Martin Nugent
01254 828060
D3/12/0870

Drafted 28 November 2012

Planning Applications, Ribble Valley District
3/12/0870 Dove Syke Nursery, Eaves Hall Lane, West Bradford

Proposed Location Plan 1:2500

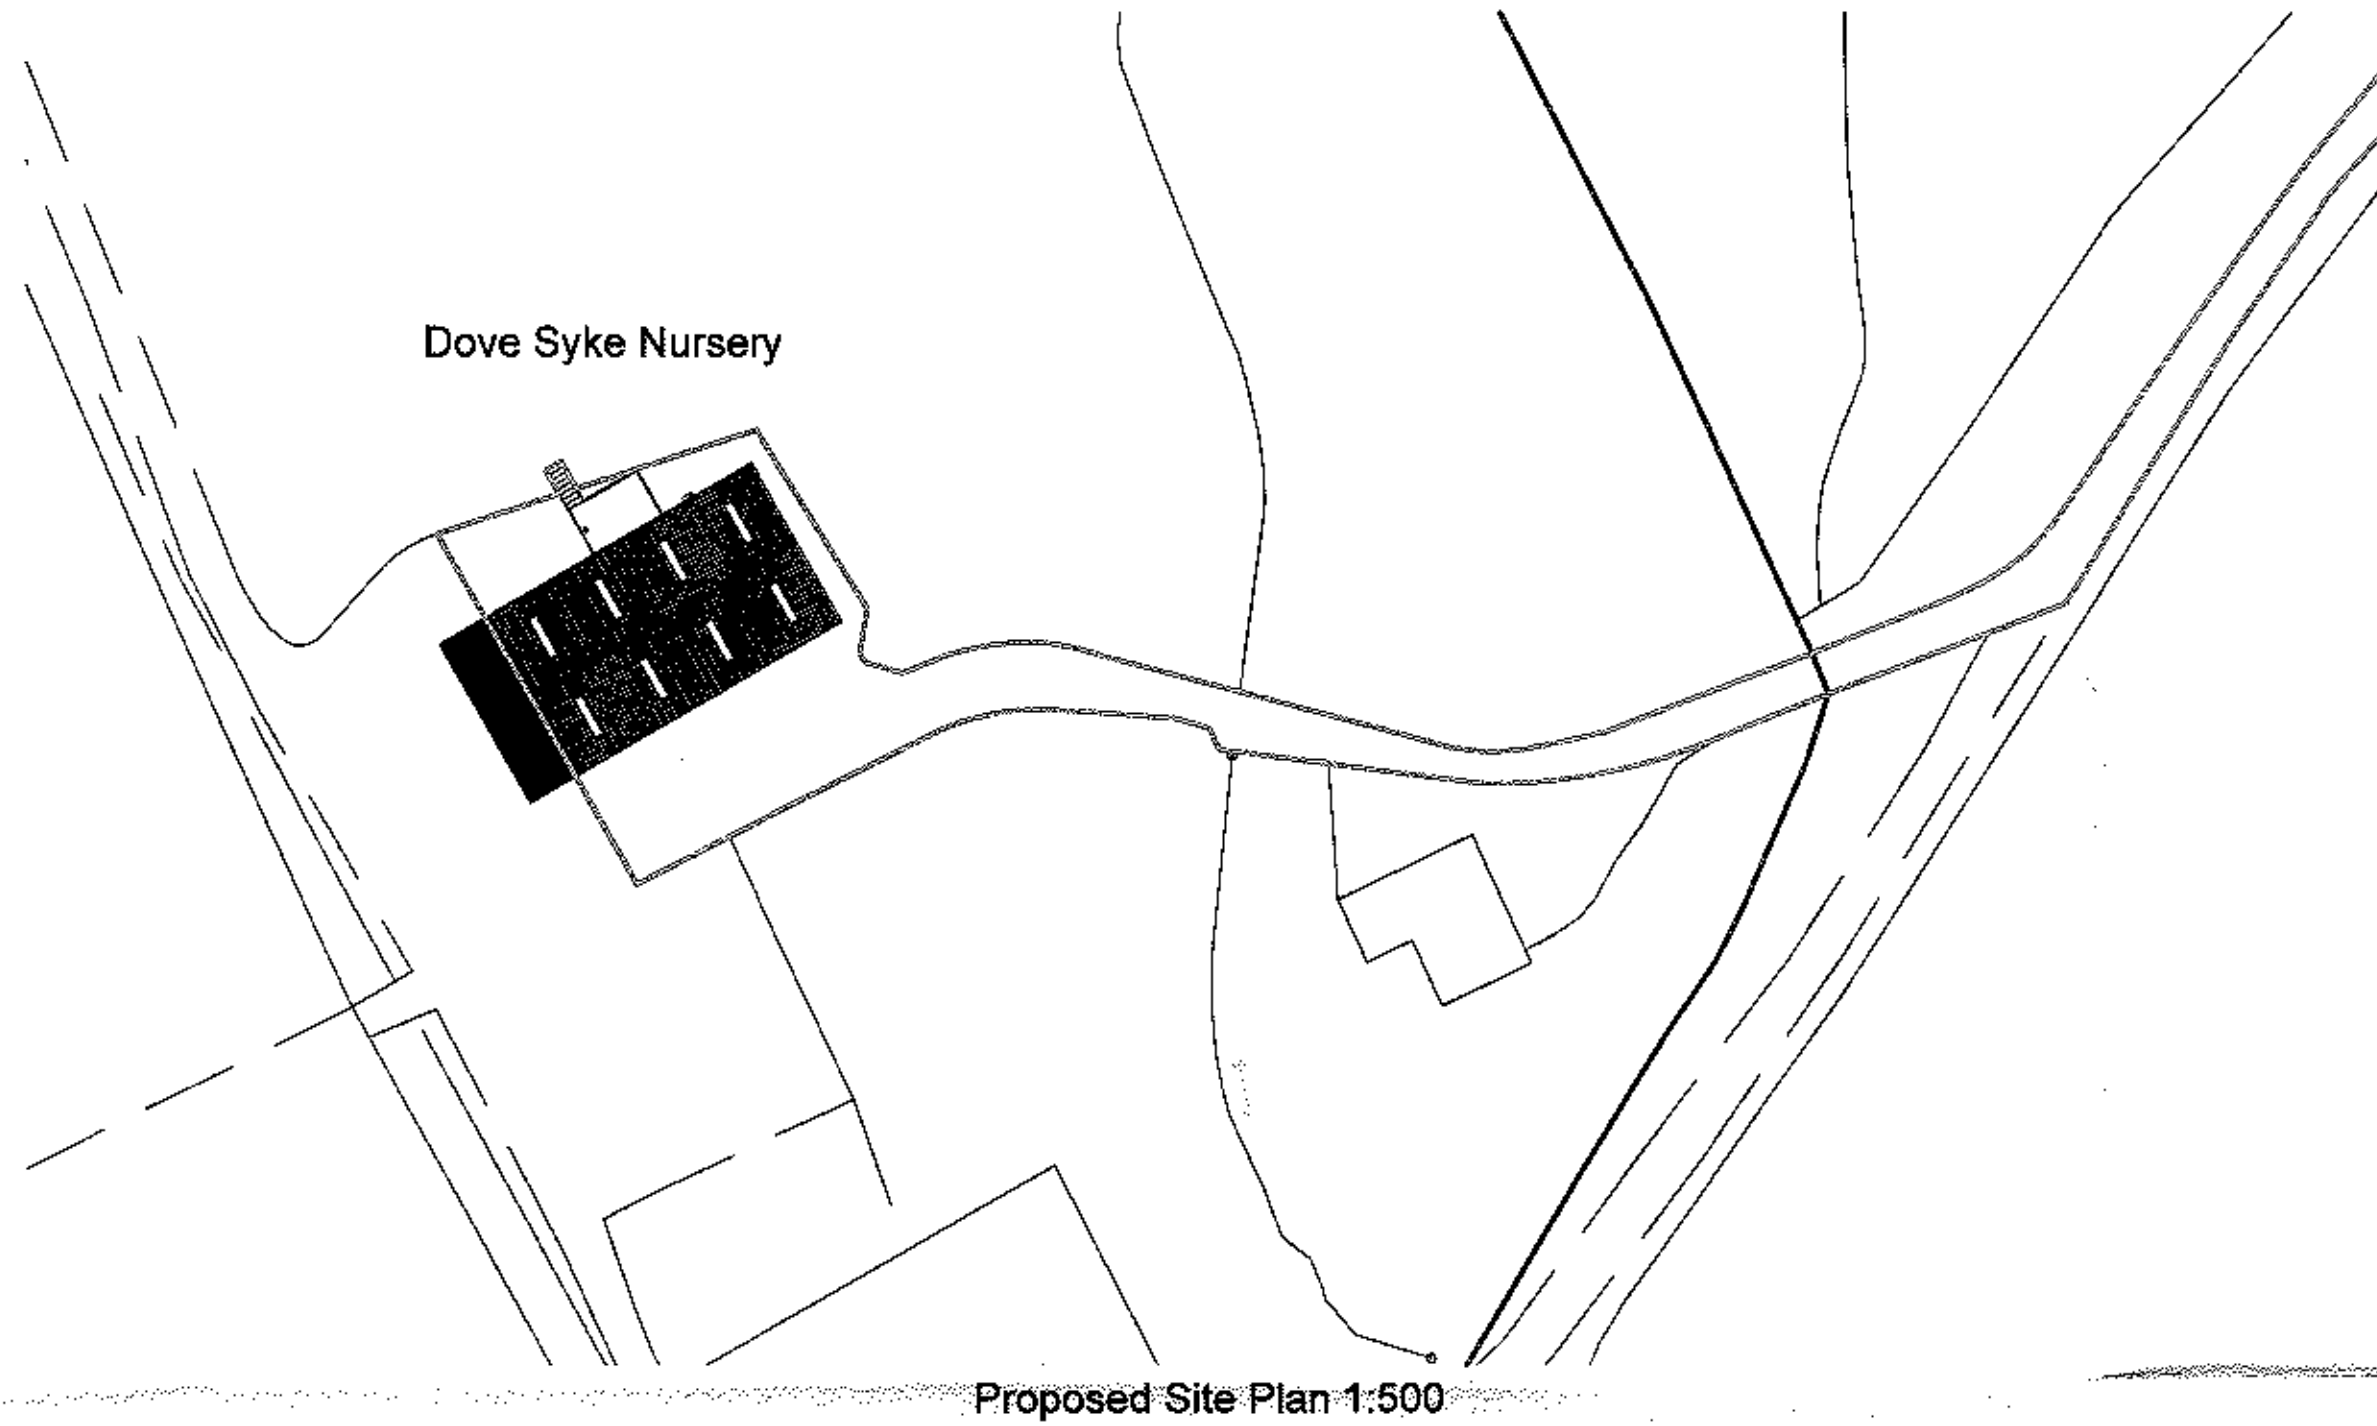
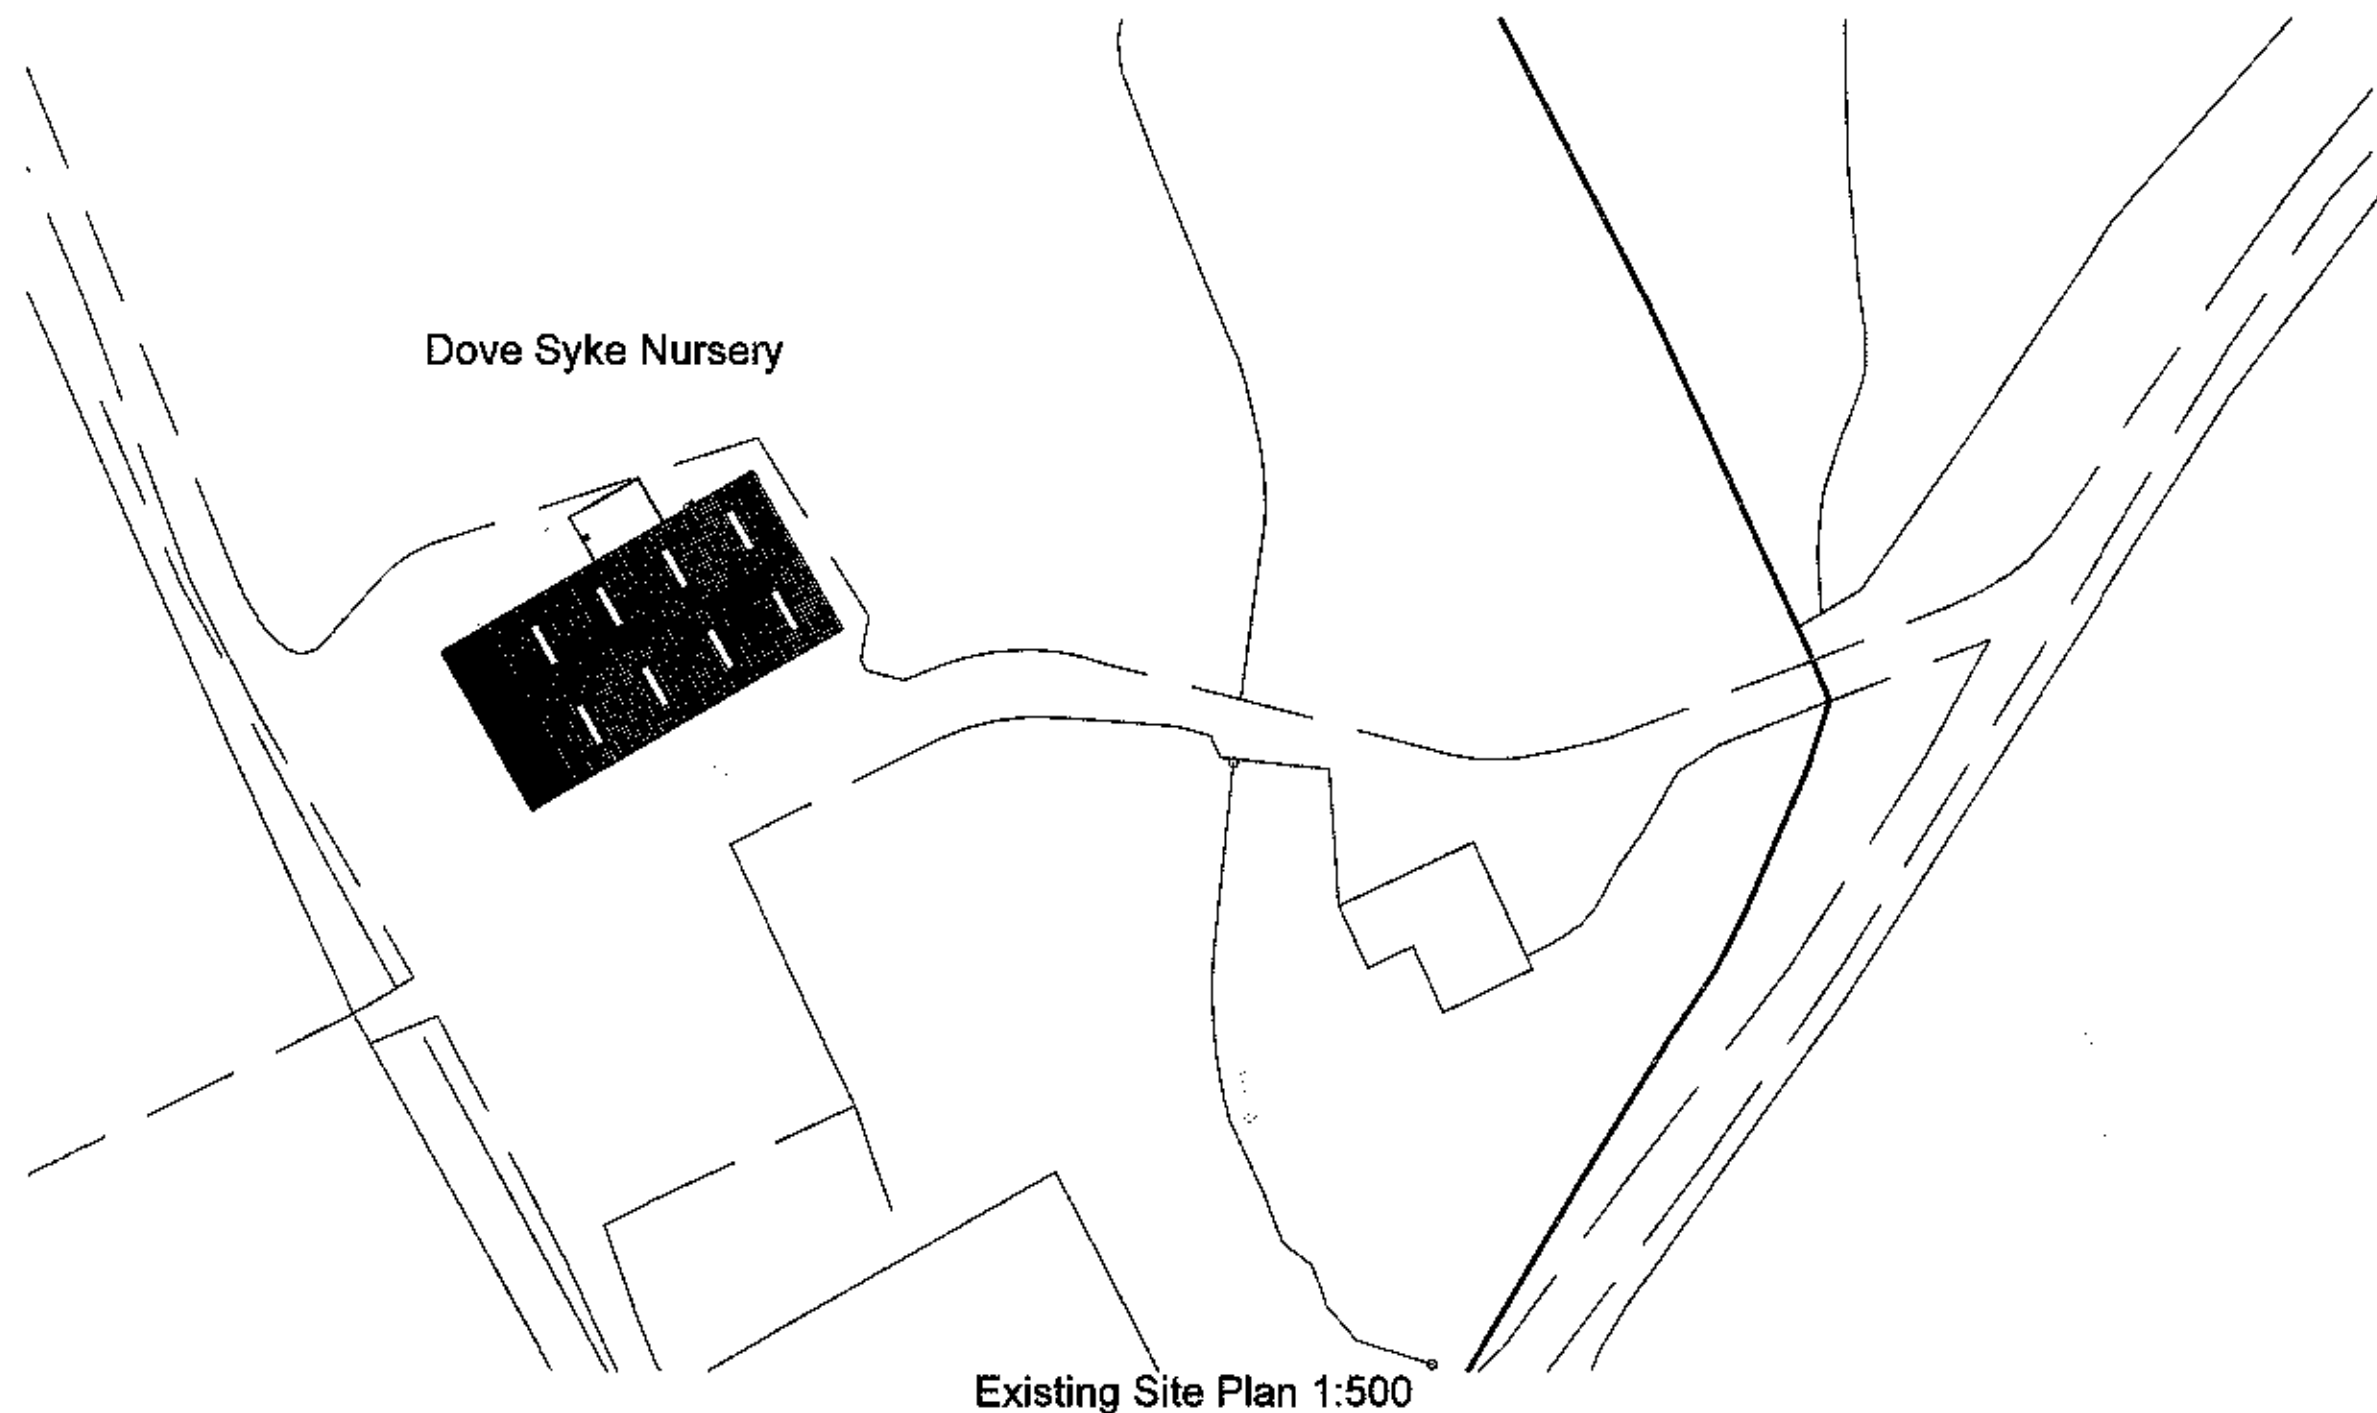
However, it will be necessary to provide a clear route to and from the holiday accommodation, distinct from and not impeded by in any way the operation of the commercial unit. This will include the introduction of designated and permanently marked parking spaces for two vehicles.

In order to address the above points, I would welcome the submission of an amended and improved site plan that identified the means of identifying an internal route to the holiday accommodation and the associated parking places.
